Application No: A/253/21/OUT
Site Address: Land between 32 Downs Way and 2 Ambersham Crescent Angmering BN16 1AB
Description of works: Outline planning application with all matters reserved for the erection of 1 No bungalow dwelling with off street parking and private amenity space.

Thank you for your internet representation made on 18th January 2022 which has been recorded as an objection with the comments as follows:

Indicative Plans and Elevations

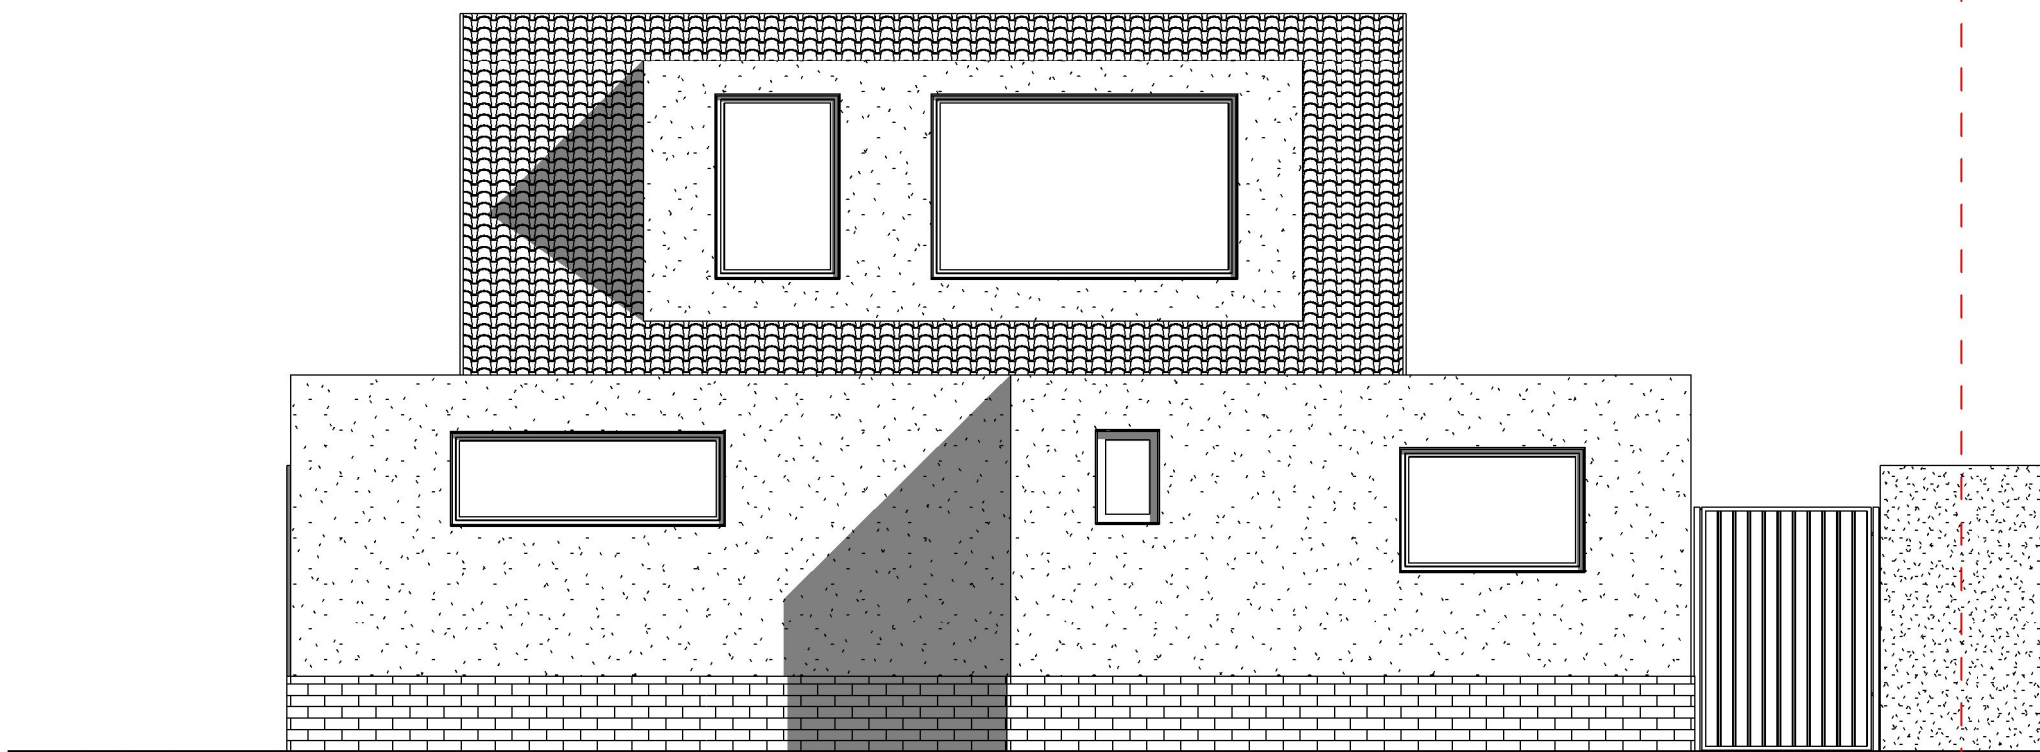
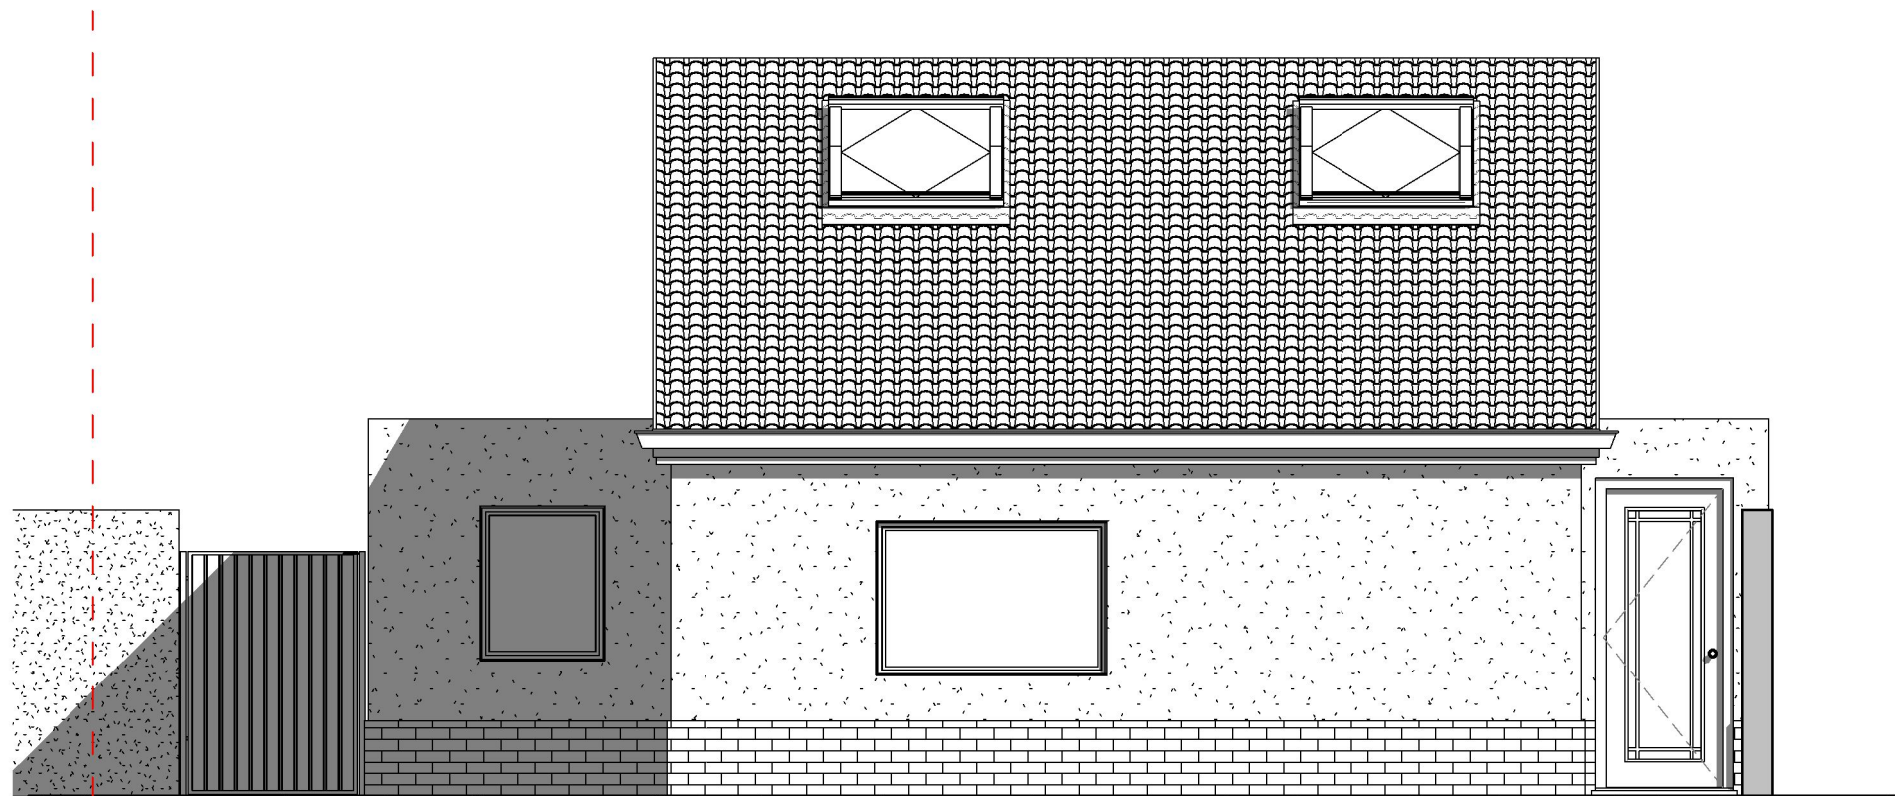
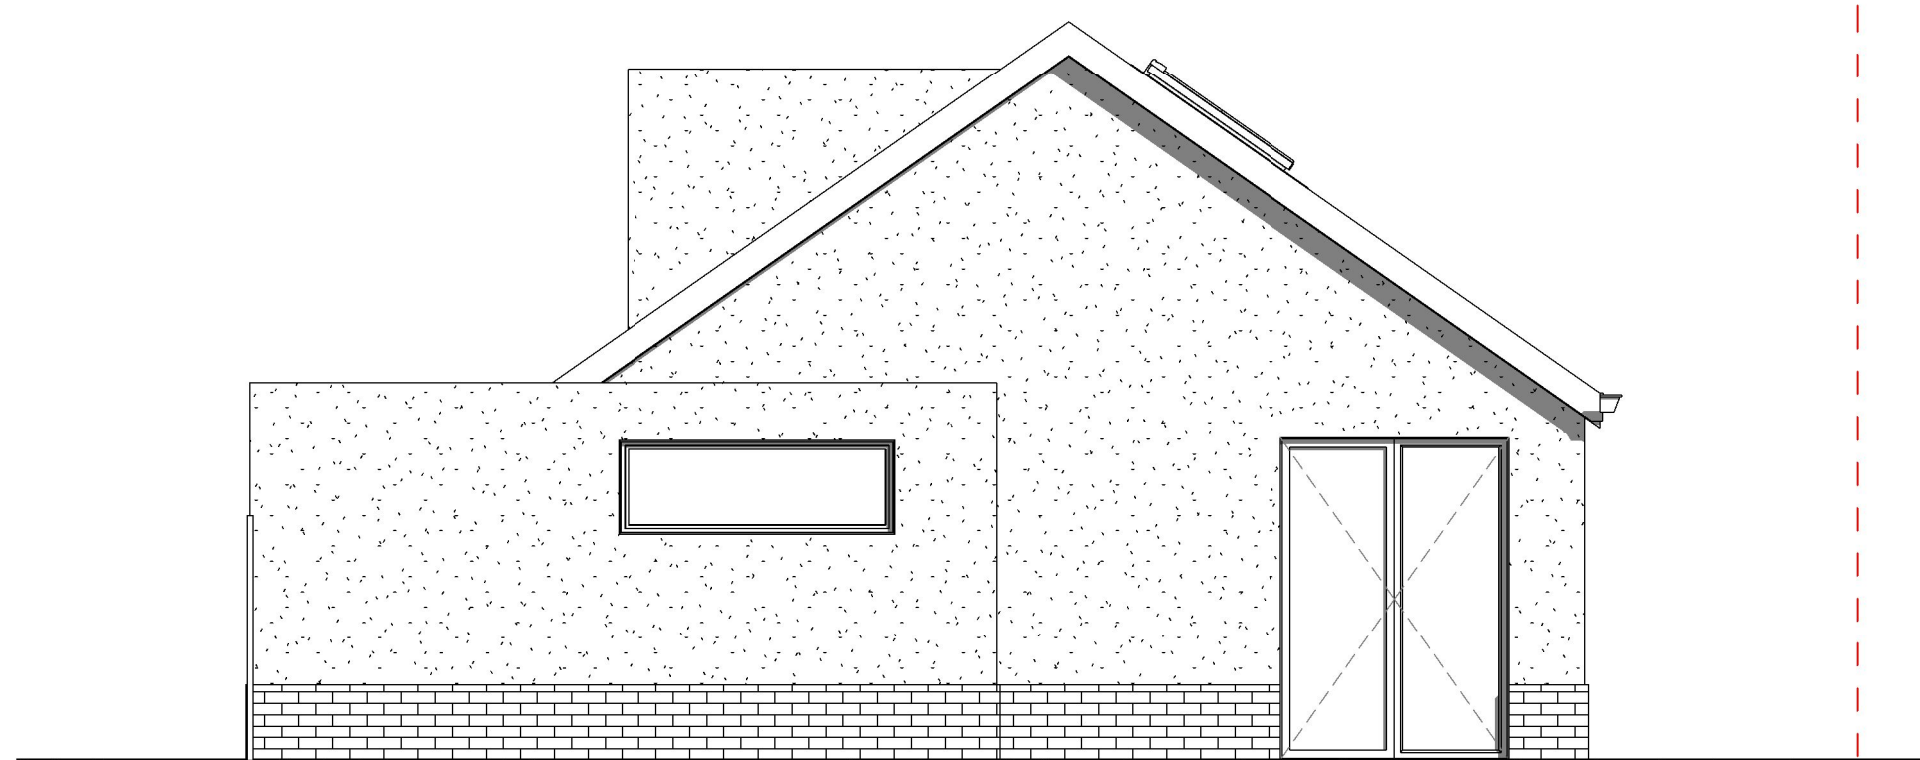
Object this planning for a 2/3bedroom bungalow. The reason why is the bench would go the diagonal path way all have been used for many years the bench was put up for the elderly to use. Objections to people privacy which will affect immediate neighbours. Object to the design of -flat roof is out of keeping with the other bungalows ,/very tiny garden and the position of it Highway safety object to its right on the junction which will make it a nightmare it's hard to come out of you drive because of parked cars it going to make it dangerous.we had to wait a longtime for the yellow lines that why we had them. Object to it that has been a green space since the estate was built wildlife /trees removal of existing well established hedges and trees which will impact on birds and bees and hedgehogs on that plot Object to this being built. It's going to take a lovely green piece of land and take away pavement and Bench away from people who live here it will look very much out of character This road is a nightmare for parked cars and traffic it's a very dangerous corner so that why we had yellow lines . It s should not happen so that's why I object to it .
